7 Goda Road
Littlehampton
BN17 6AS

Ref application number **LU/13/15/PL**

We wish to object to the current proposal for development of the Old Dairy site for the following reasons:

SOUTH ELEVATION PLOTS 1 TO 5 PROPOSED

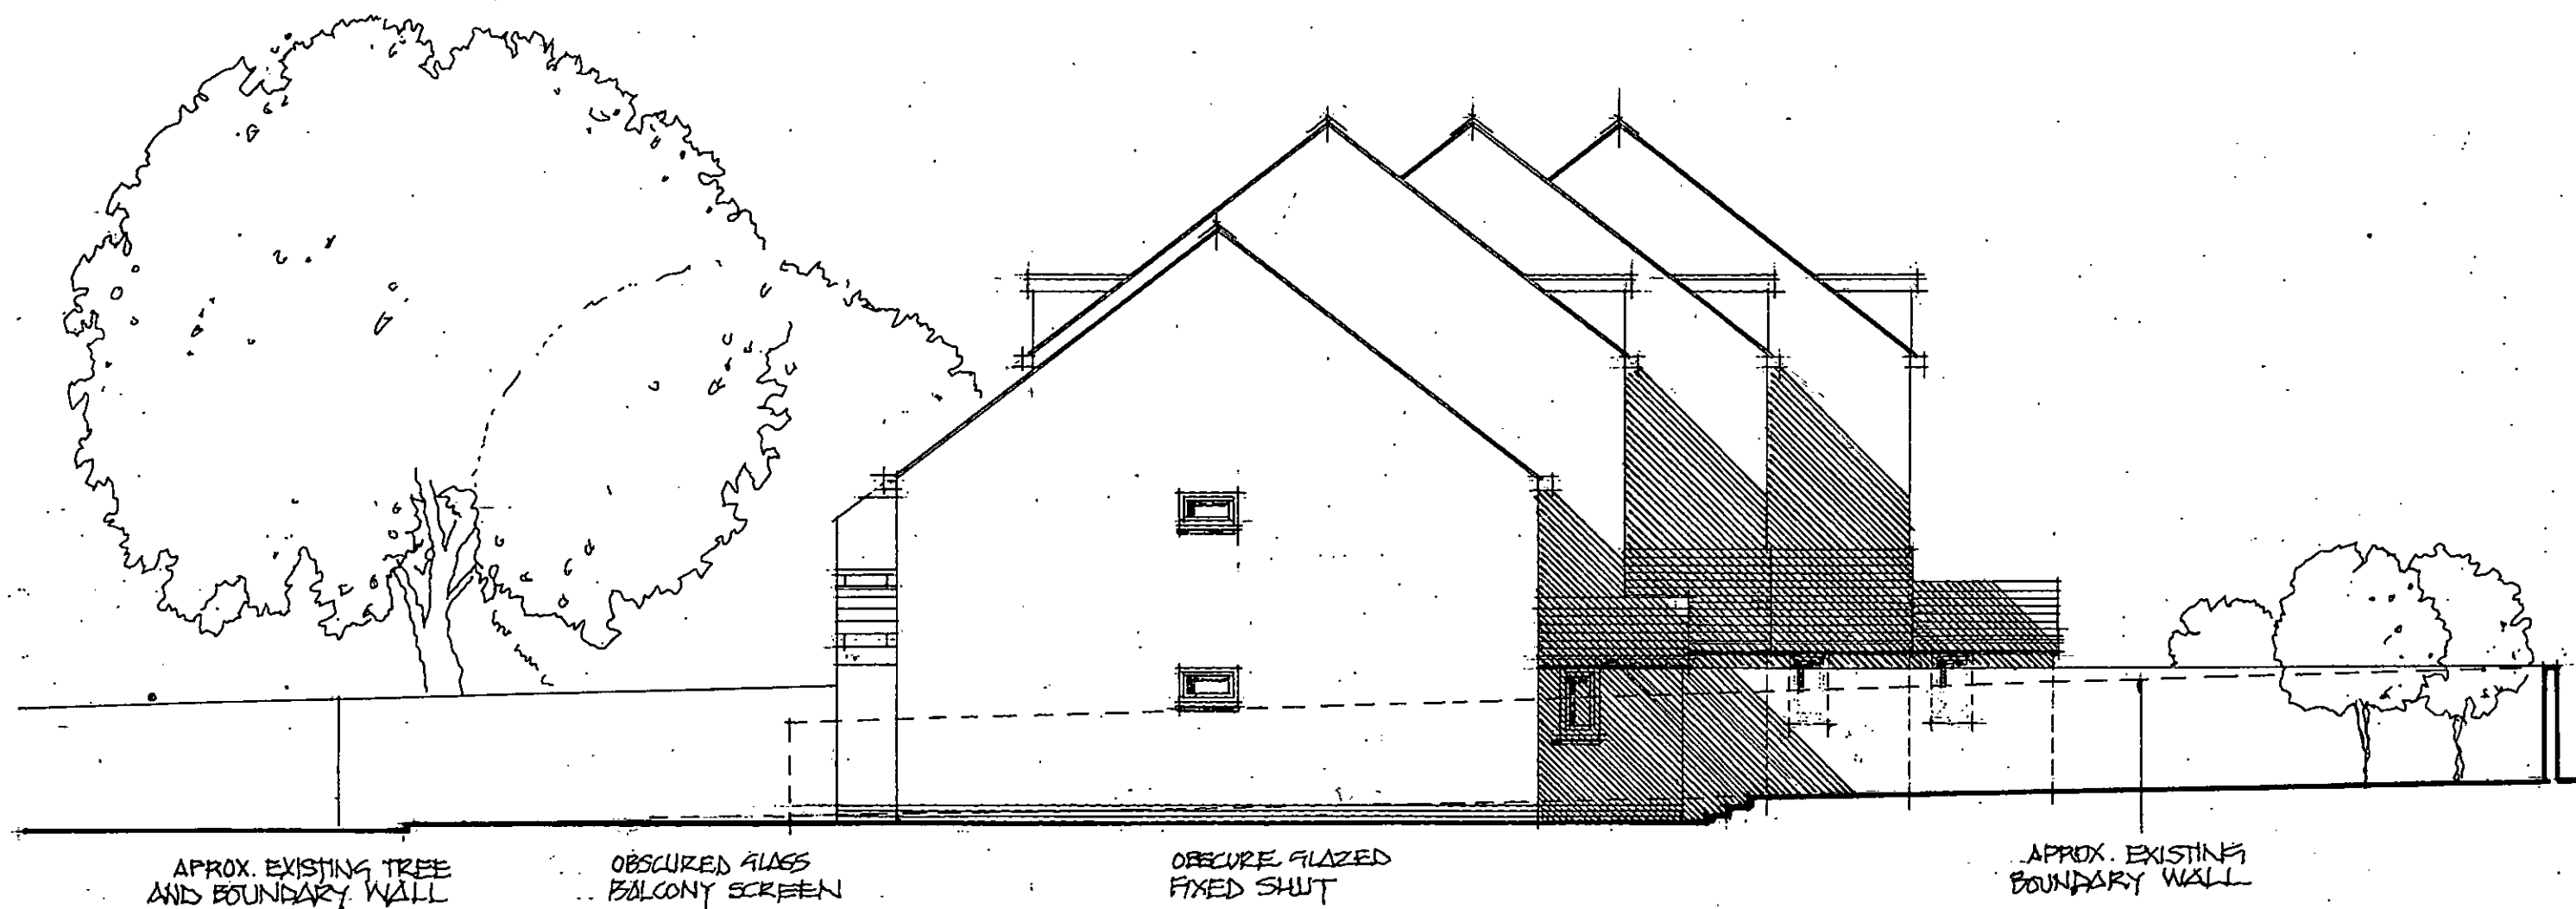
1. **Overlooking, overshadowing, loss of light and loss of privacy:** The proposed development plan shows plots 3 - 5 and 6 – 8 as being three storey/two-and-a-half storey buildings. Being of similar

height to or higher than adjacent buildings, these will overlook, overshadow and result in loss of privacy and loss of light to adjacent properties including our own property and garden. The Flintstone Centre will be particularly badly affected by these negative impacts, as the site on which it is built is on a much lower level than the Old Dairy site so the proposed plots 5 - 8 will tower over it, overshadowing and overlooking the Grade II listed building and resulting in loss of light to the east facing aspect and windows, and loss of privacy. Being on the east side of plots 5 – 8 our own property will lose daylight and sunlight and will be overlooked by the north aspect of plots 5 – 8 resulting in a loss of privacy.

3. **Three storey/two-and-a-half storey houses:** The plan suggests that it is in keeping with the area to build two-and-a-half storey buildings. However, the fact that some of the neighbouring buildings on Goda Road are three storey buildings or of varied height should not be cited as a reason or excuse of itself to build three storey / two-and-a-half storey houses, as the existing houses are buildings of character and any modern developments should be sympathetic to rather than competing with the existing properties.

4. **Scale and massing:** The site is too small for 8 units, particularly when 6 of them are two-and-a-half storey, three bedroom houses. This is evident in the inadequate spatial separation of plots 5 - 8 in relation to the Flintstone Centre and the east boundary wall/properties.
